**Re: Phase 1 Bedrock at The Trails by La Terra Development at 9300 Woodmont Ave. NW  
Erosion and Sediment Control Plan for Tracts 4 and 5 of the Trails Unit 3A  
Engineer's Stamp Date 4/4/24 (C09E011B)**

Based on the information in your submittal, received on 4/4/24, the above-referenced ESC Plan cannot be approved for a Work Order and Building Permit until the following comments are addressed.

# STORM DRAIN POND A6-2 TO POND D1

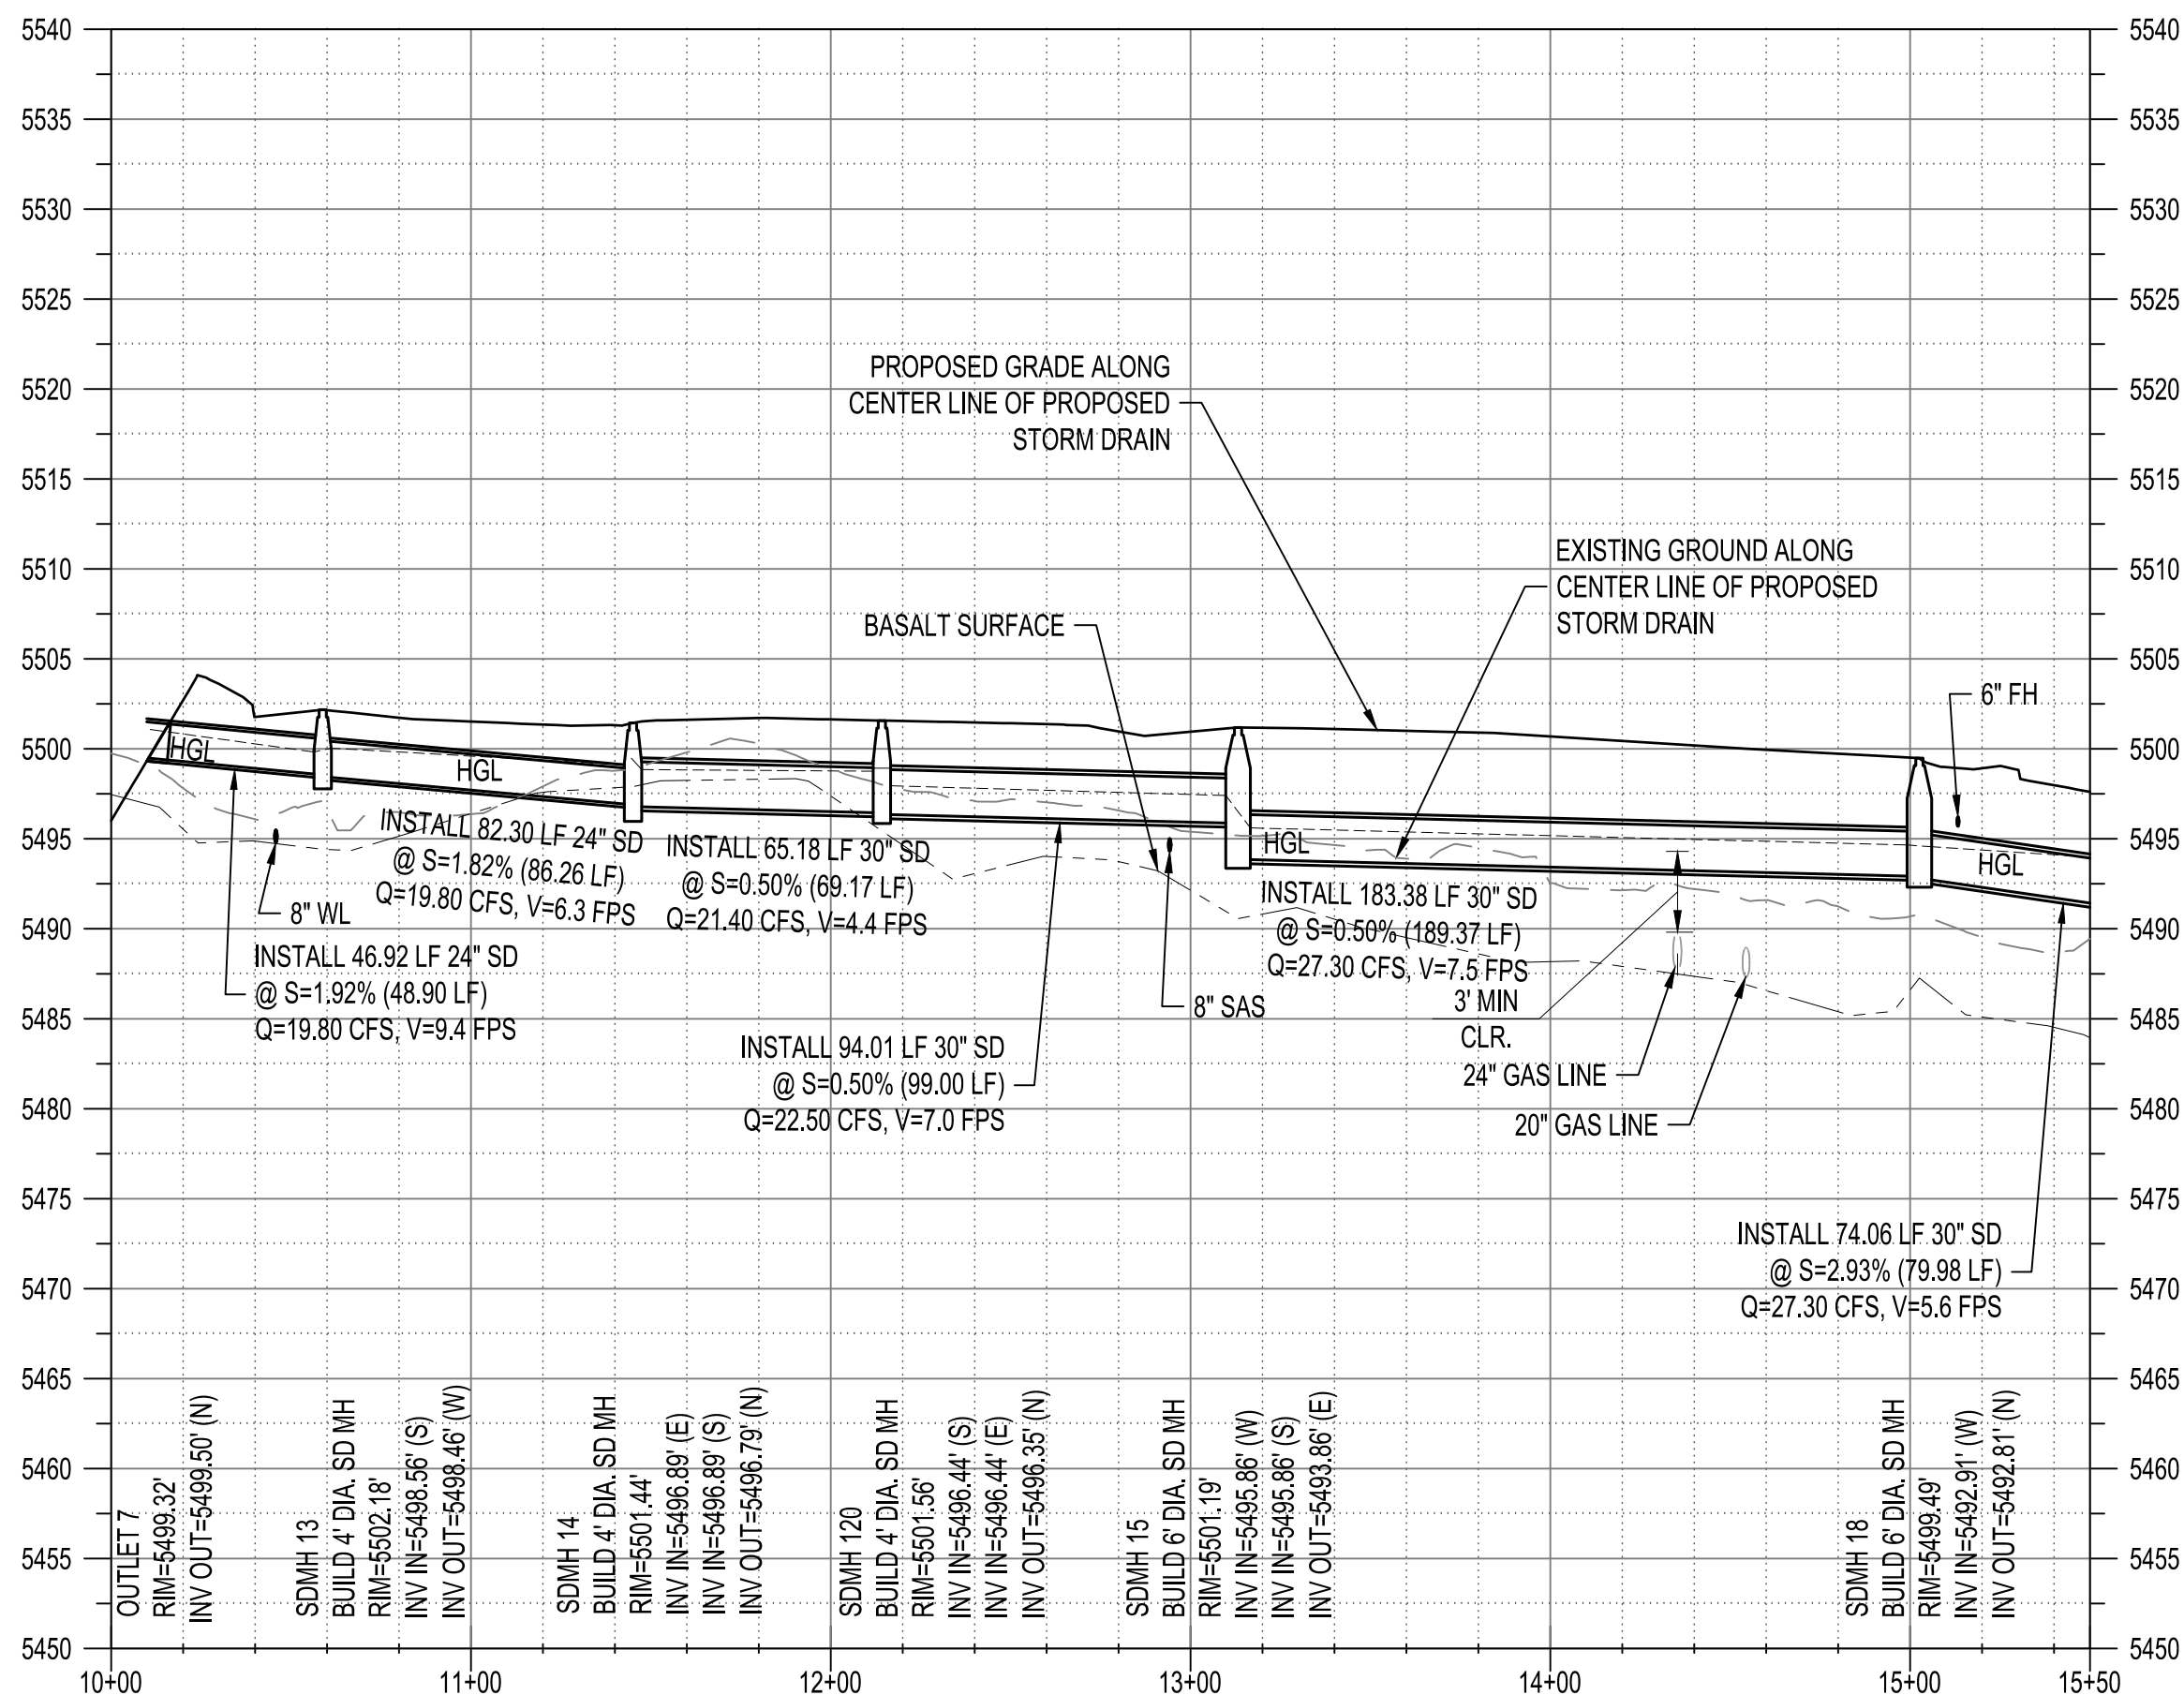
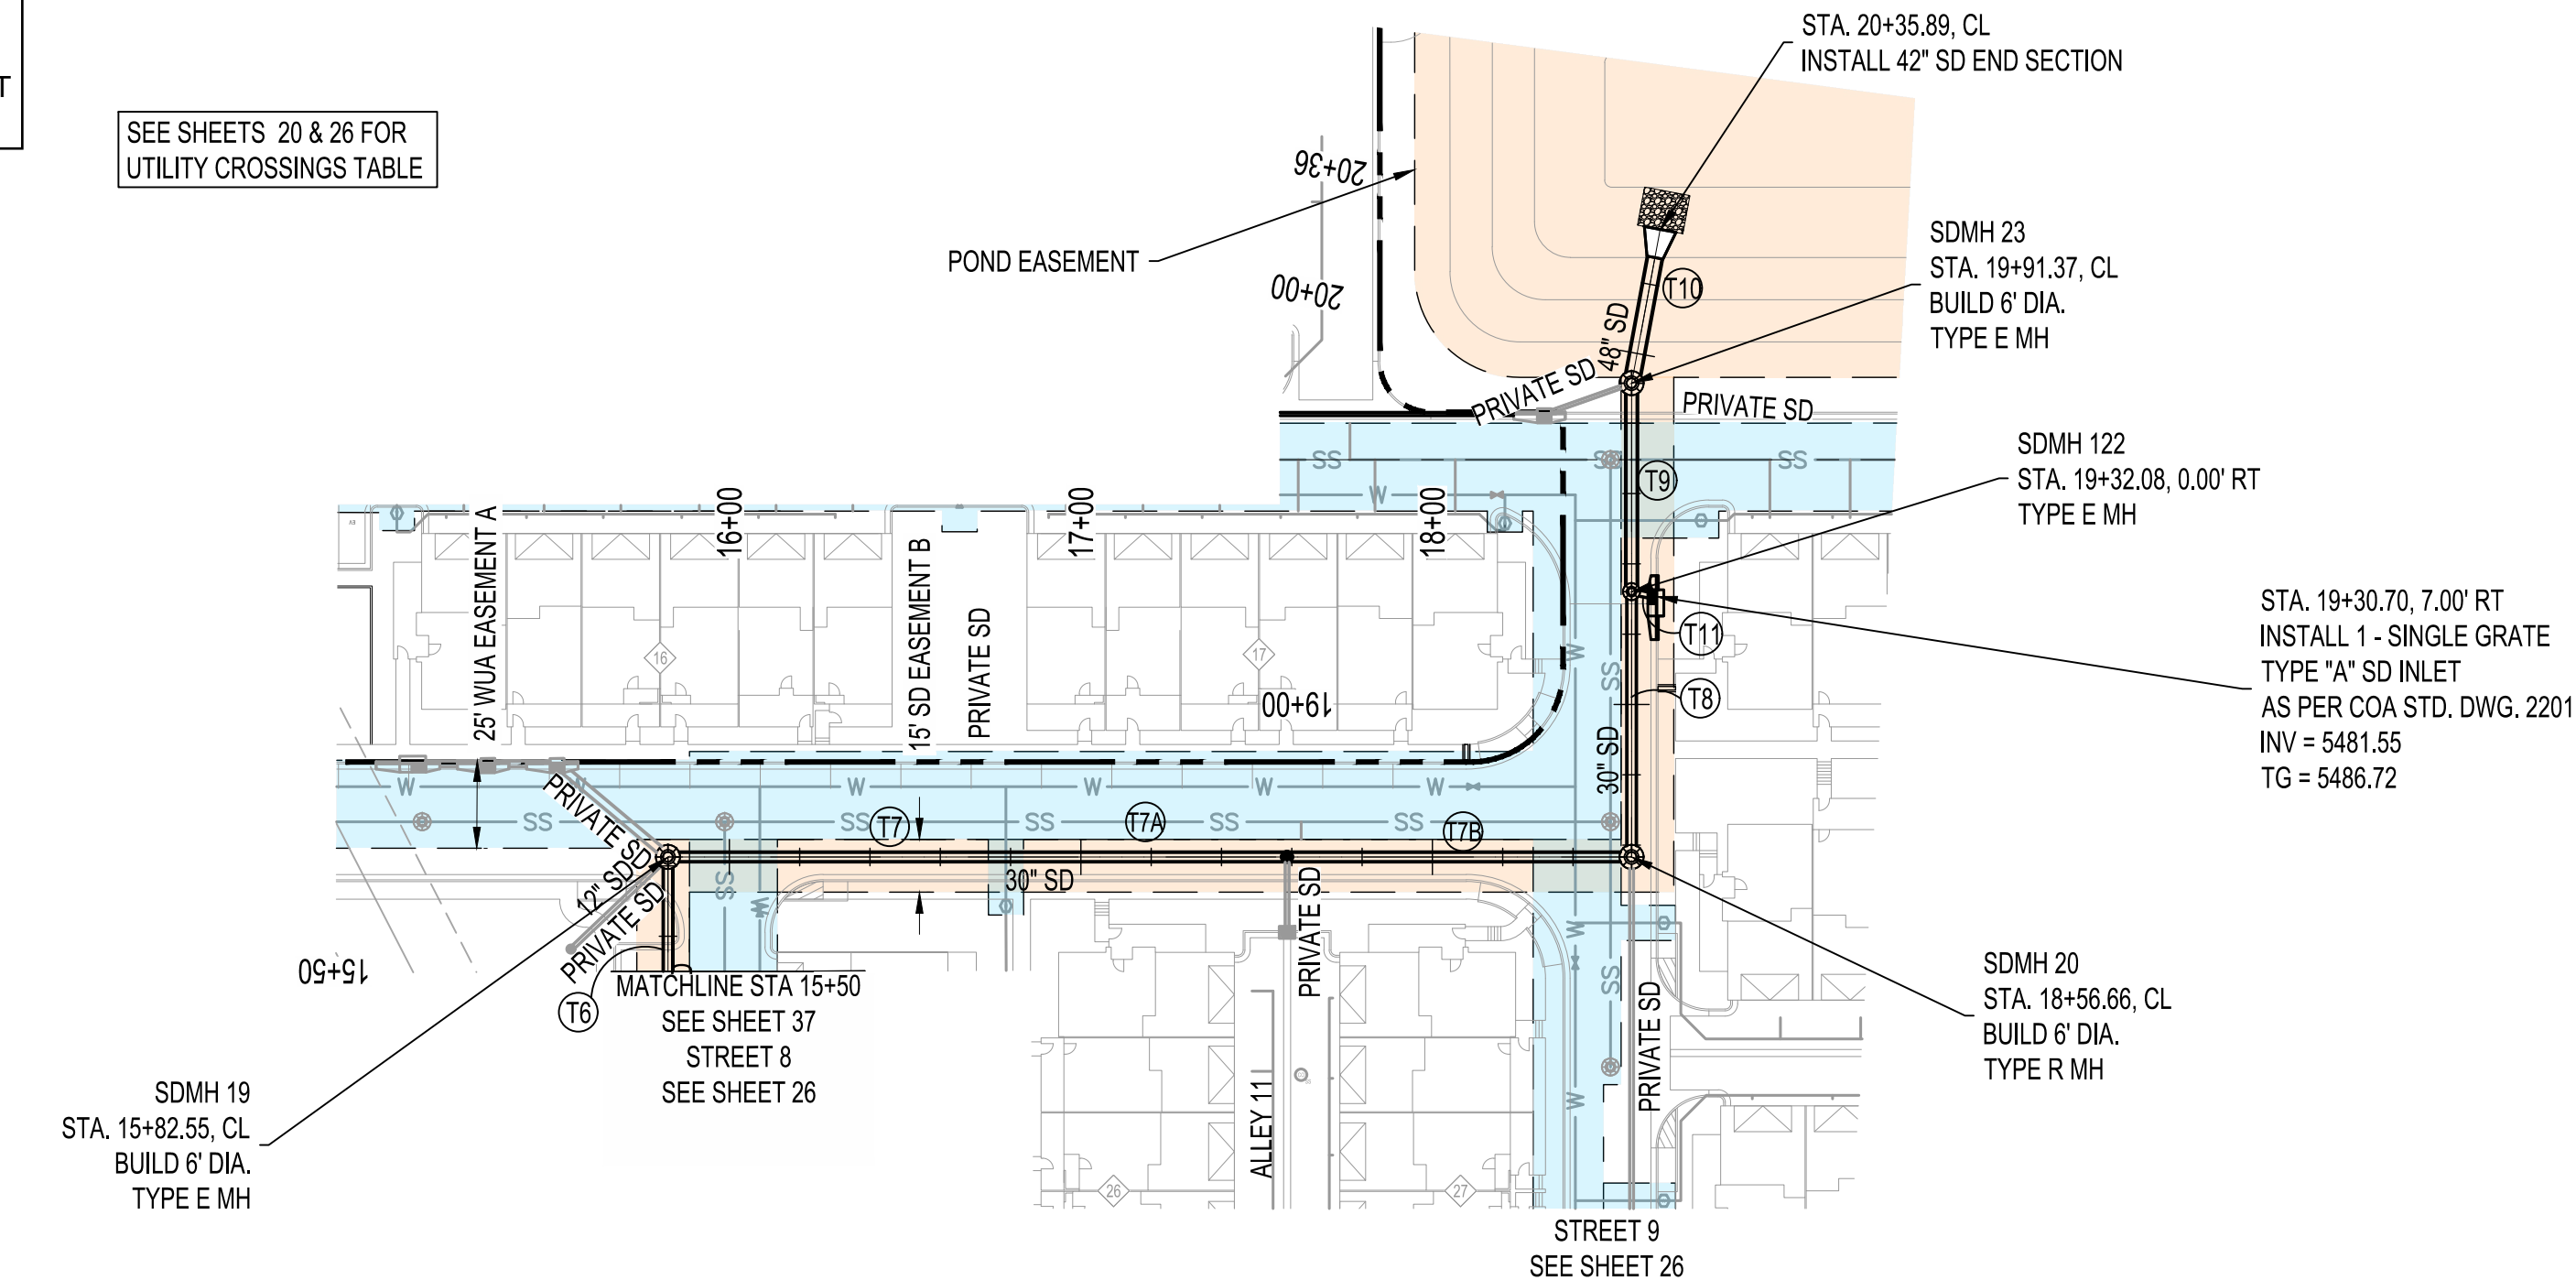
the notes on Work Order pages 37 and 38 from constructing the D-1 outfall during Phase 2 to the end of Phase 3 and verify the timing of the outfall from Pond A6-2 to D-1.
